14 June 2018

RE: 1 DENISON STREET, NORTH SYDNEY – MP 08_0238 MOD 10

I refer to your letter of 30 May 2018 inviting North Sydney Council to comment on the proposed modification No.10.

Site Plan

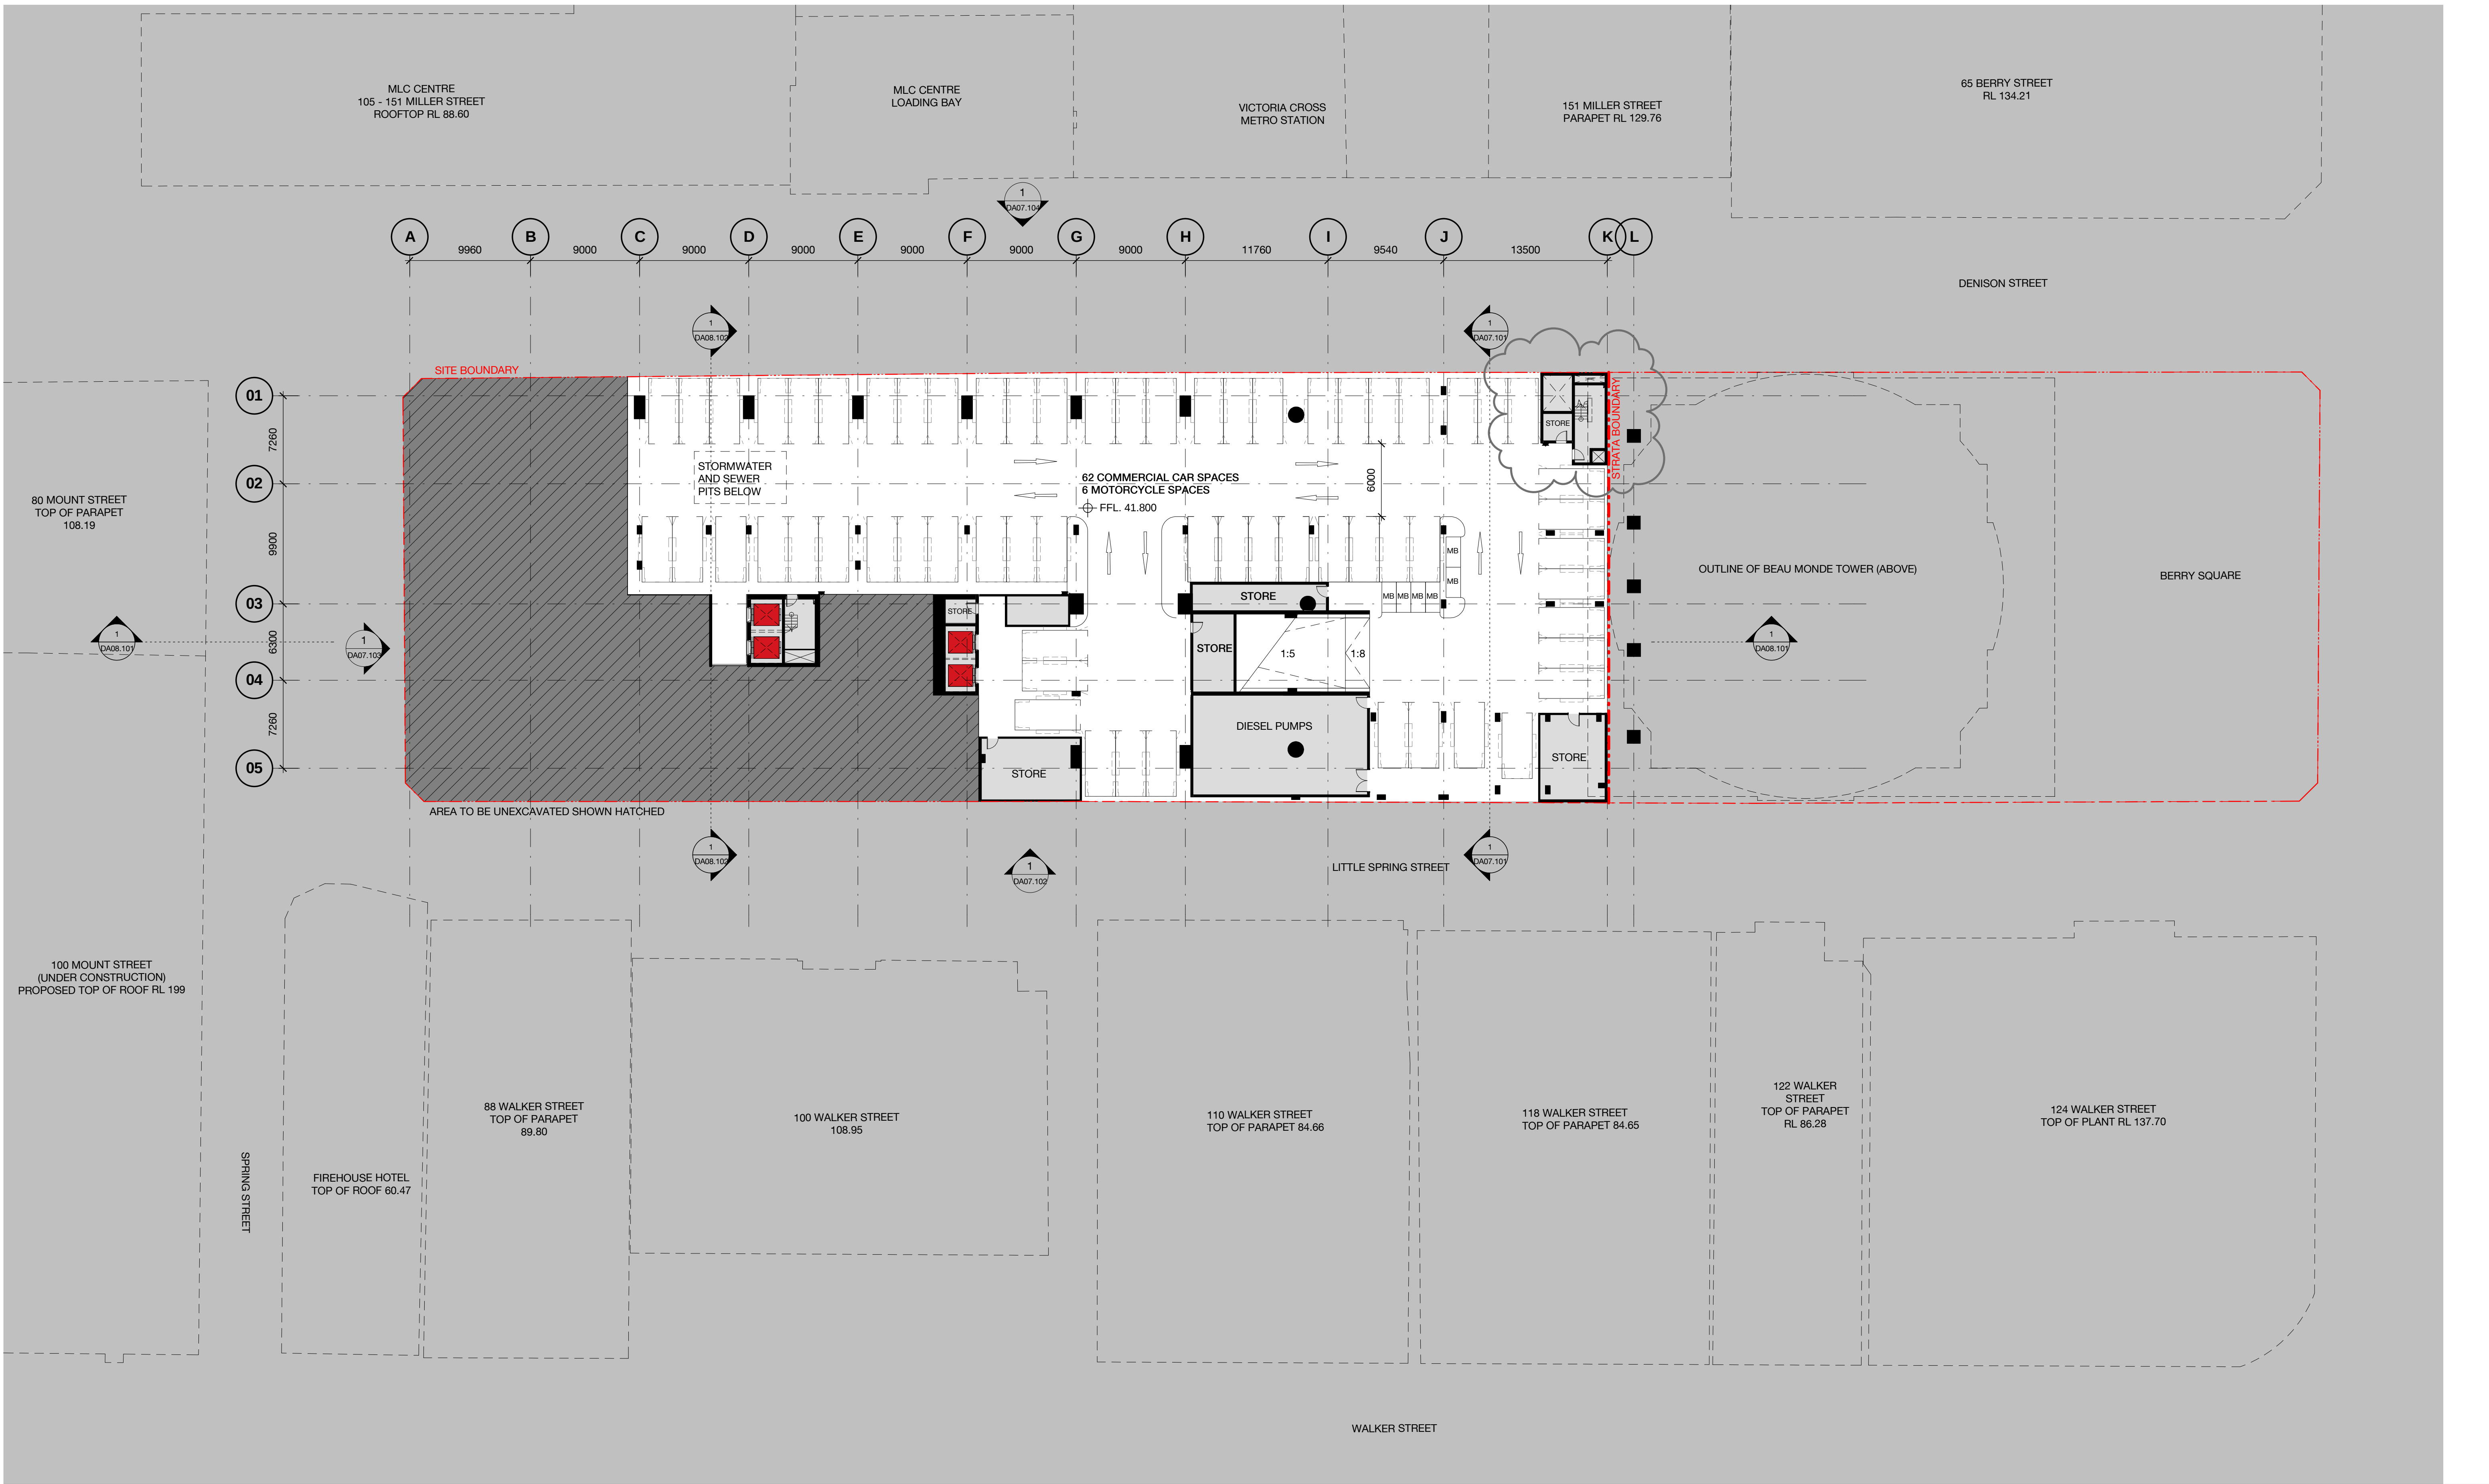
Council raises no objection to the updated landscape design for Berry Square as this had been discussed with Council previously. Council does raise concern with the two electricity substations shown on the Landscaping Plan for Berry Square. These substations were temporary locations during construction at 1 Denison Street to provide power for the construction site and for Beau Monde after the Shopping World building was demolished. Council was advised that the substations would be removed when the substations in the new building were commissioned. This was also an issue for residents of Beau Monde. It is requested that the substations be removed off the plans so that they are not included as part of the approval or that a condition be imposed requiring the substations to be removed prior to the final Occupation Certificate for the proposal.

Indicative section through tower lighting at the crown. (Not to scale)

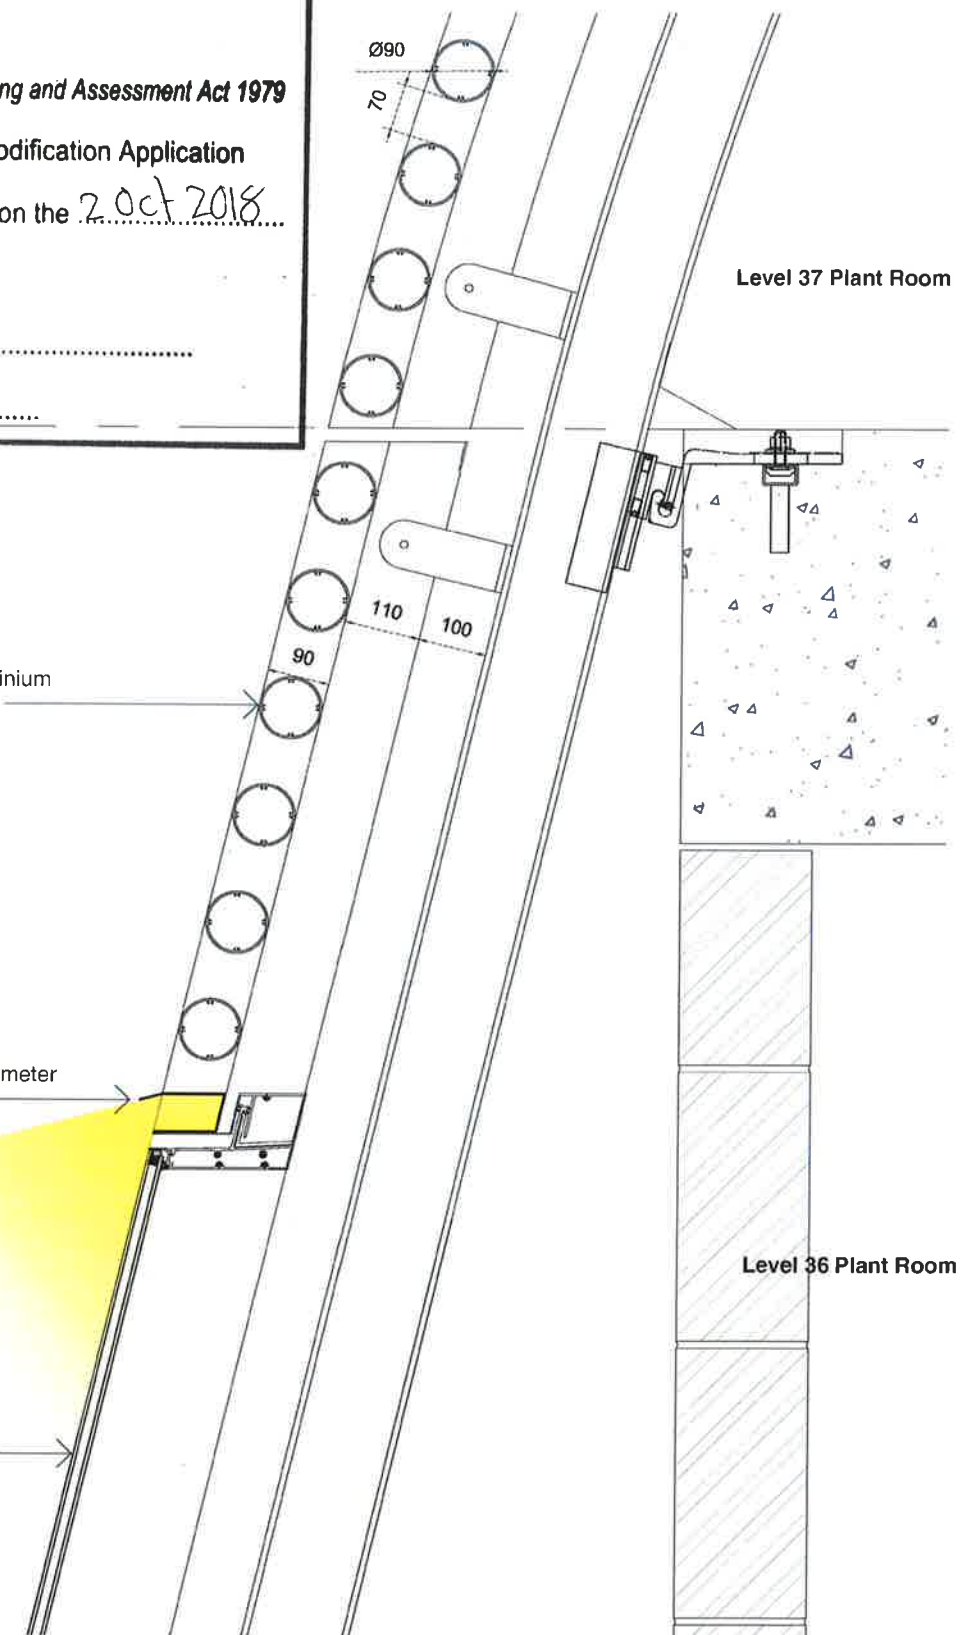
Council has no objection to the changes to the building proposed. Council suggests that the lighting of the roof profile might be referred to the Sydney Observatory for comment as concerns have been raised in the past by the Observatory with some of the roof signs in North Sydney CBD.
